DELEGATED ITEM FILE REPORT - APPROVAL

Application No:	3/2014/0776
Development Proposed:	Erection of detached two-storey dwelling with accommodation in the roof space within the side garden of No.9 Fox Street. 9 Fox Street, Clitheroe BB7 2AQ.

First Floor Plan

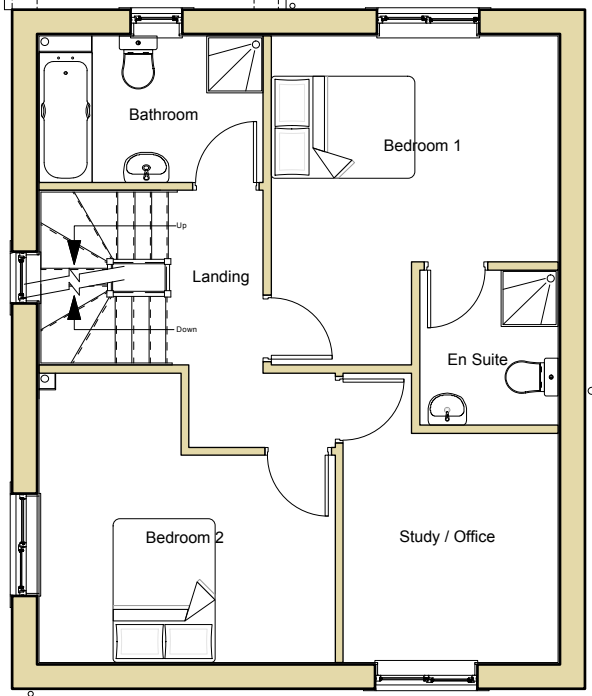
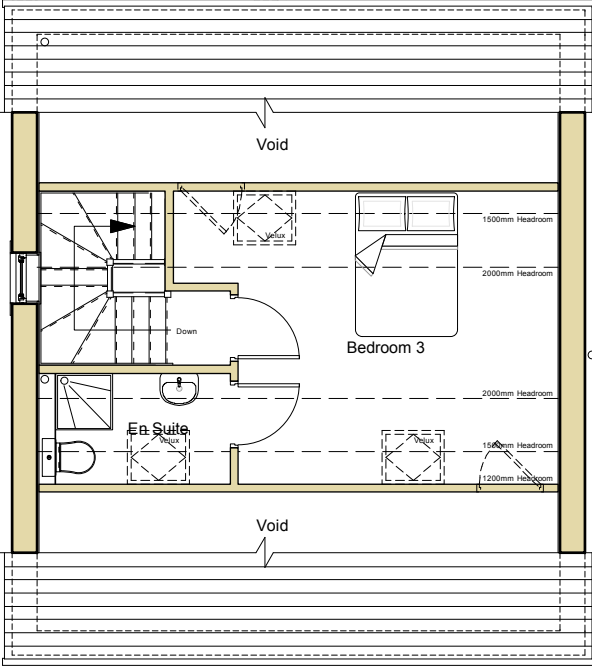
Amendments to the proposal have been sought that relocates the first floor window serving bedroom no.2 from the south elevation to the west negating any direct overlooking/privacy issues in respect of the existing properties to the south. It is noted that a south facing study is also located at first floor, a condition will be attached that requires this window to be obscure glazed to protect existing residential amenity.
